Our Reference: SYD17/00935 (A21143355)
DP&E Ref: SSD 8606

Marsden Park Warehousing and Light Industrial Estate (SSD 8606) - Lot 23 and Lot 24 DP 262886 Hollingsworth Road, Marsden Park

Roads and Maritime has reviewed the submitted documentation and the following issues are to be addressed prior to the determination of the application.

ESTATE MASTERPLAN PLAN

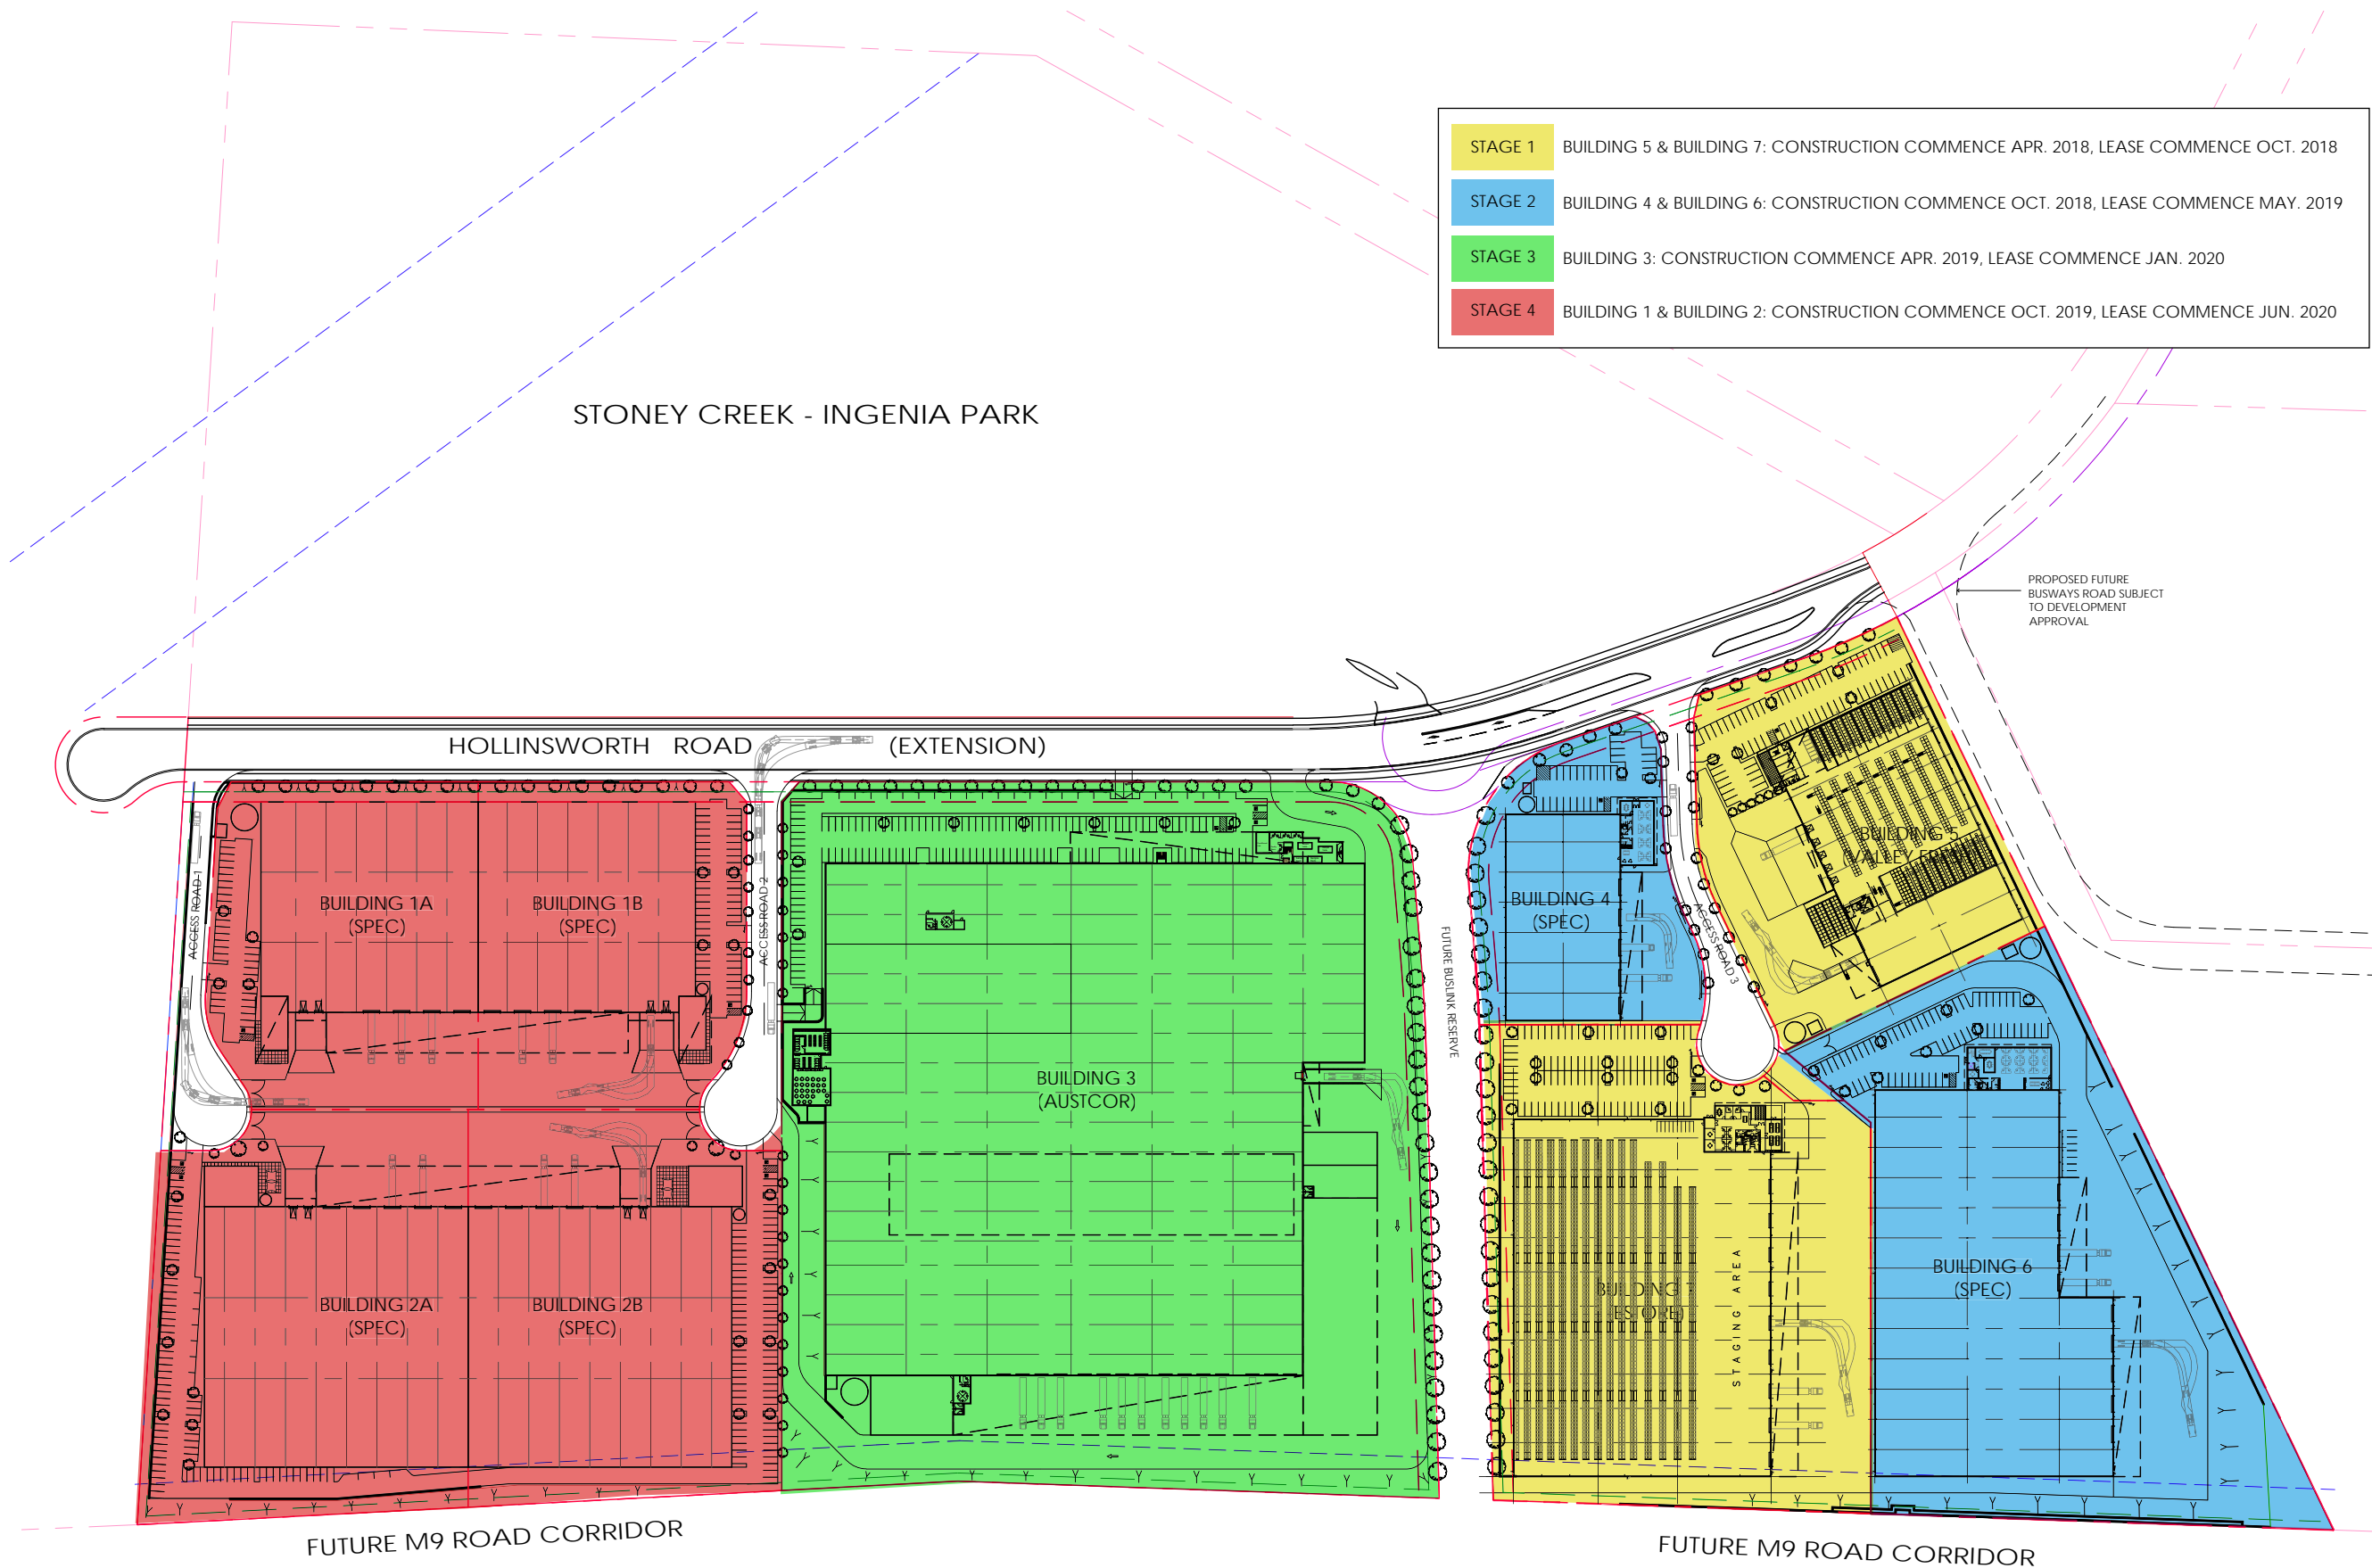
1. The traffic report refers to a roundabout at the intersection of Hollingsworth Road and Daniel Street link Road. Roads and Maritime considers the provision of a roundabout is critical at this intersection to assist in the turning movements of buses and to provide access to the existing caravan park. The intersection treatment proposed will not allow access from the future bus link as the right turn bay into the caravan park would restrict turning movements. The roundabout should be constructed as part of this development to facilitate access to the caravan park without restricting access for the bus link road into the future. The applicant should design a roundabout that can accommodate heavy vehicle movements and bus movements. The design of this roundabout should be in accordance with Austroad Road Design Guide Part 4B - Roundabouts

2. It is unclear as to the width of the bus link road as there are no dimensions shown on the plan or any dimensioned cross section to ensure this carriageway is bus capable. These dimensions should be provided and the application referred to Transport for NSW and to Roads and Maritime for comment on the suitability of the road width to accommodate predicted buses.

4. The proposed heavy vehicle access to Building Three should be restricted to left in only. It is recommended that the splitter island (for the above discussed roundabout) be extended to restrict access. The raised median is to extend 10 metres west of driveway.
5. The proposed roundabout will need to be presented to the Blacktown City Council Local Traffic Committee (LTC) meeting prior to the determination of the application.
